Approval of Reserved Matters following Outline Approval BN/15/11 for Appearance, Landscaping, Layout and Scale for 75 dwellings. Departure from the Development Plan and Affects a Public Right of Way.

Land at Goodacres Barnham West Sussex

Thank you for your internet representation made on 29th April 2014 which has been recorded as '**an objection**' with the comments as follows:

Plots 61 & 62

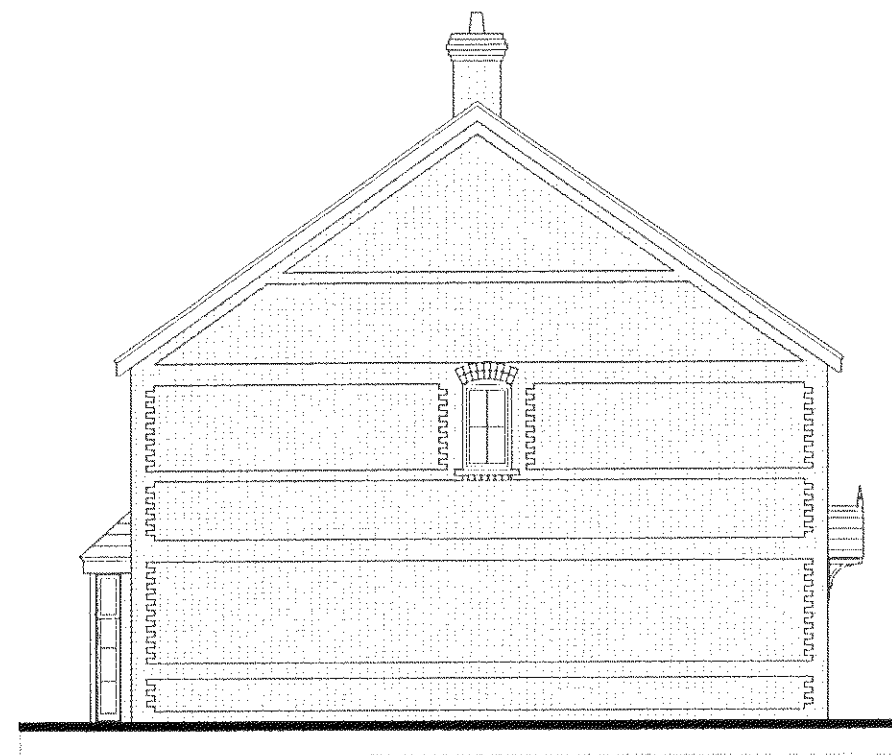
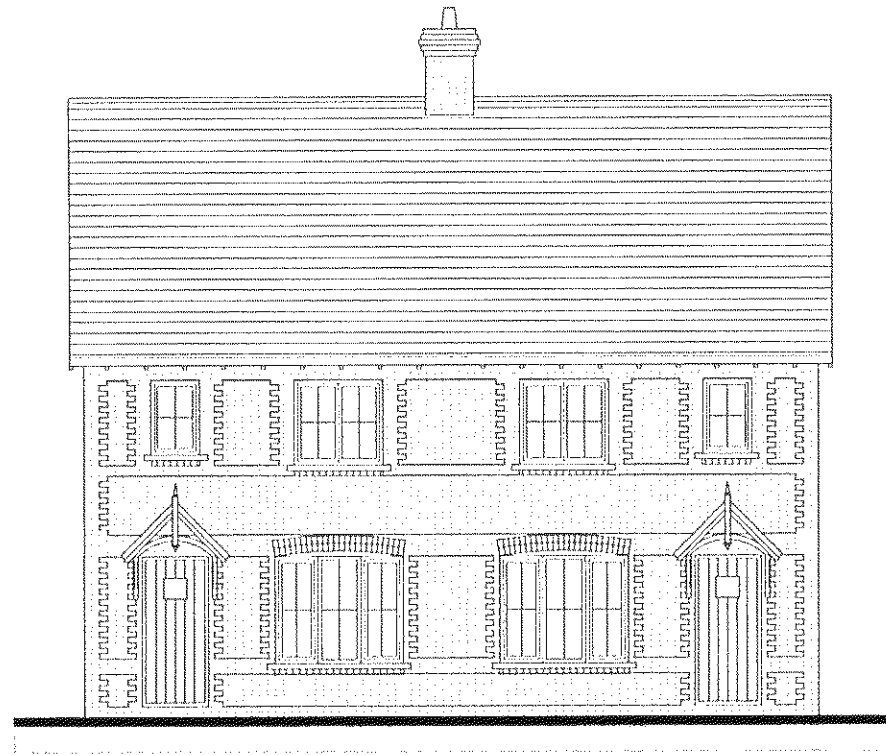
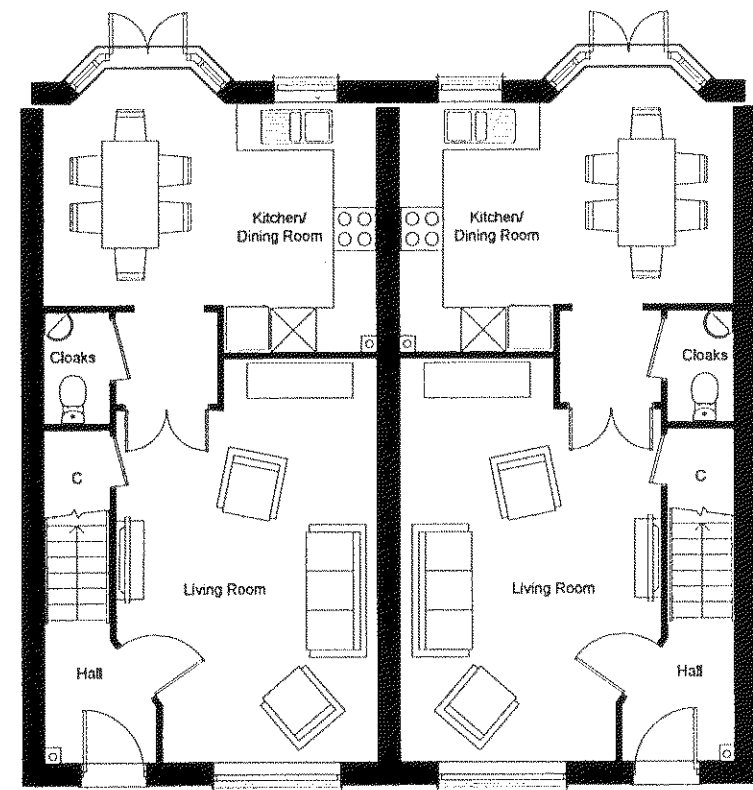
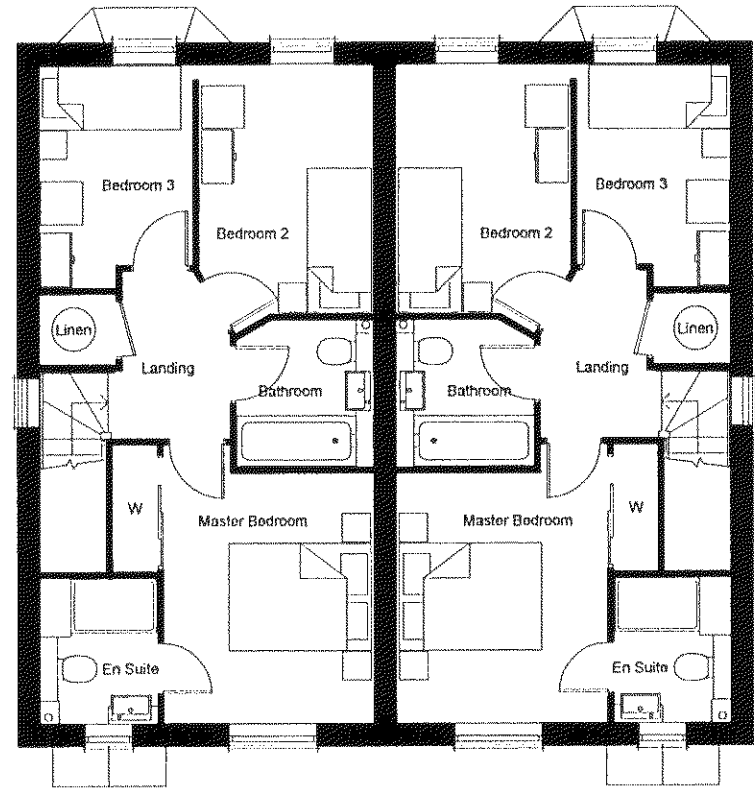
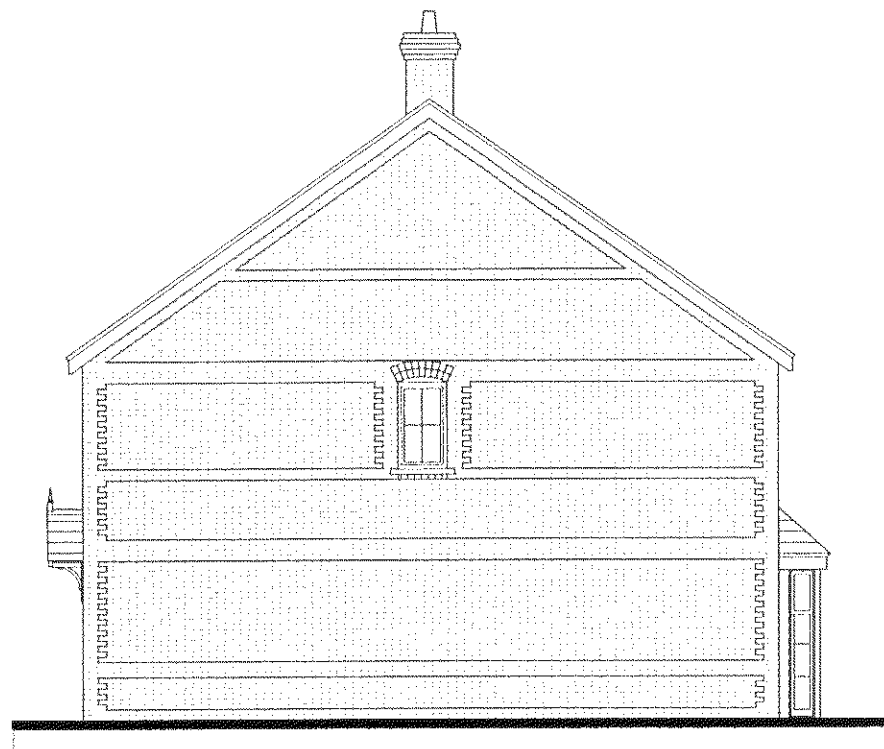
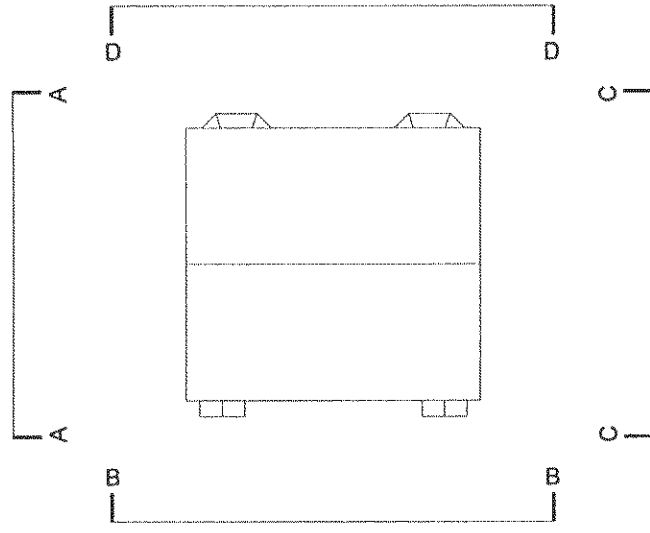
I would like to make a strong objection to the type of properties that are proposed on plot numbers 59, 60, 61 and 62 as, if as currently proposed these properties are 2 story dwellings, the upstairs windows will look directly into the bedroom and lounge of my property which they will all overlook and this is obviously completely unacceptable as it would be a gross infringement of my families privacy. I would welcome a meeting with Mr Crowther to asses this situation prior to any final planning decisions being made. I have expressed this concern verbally to Mr Crowther also.
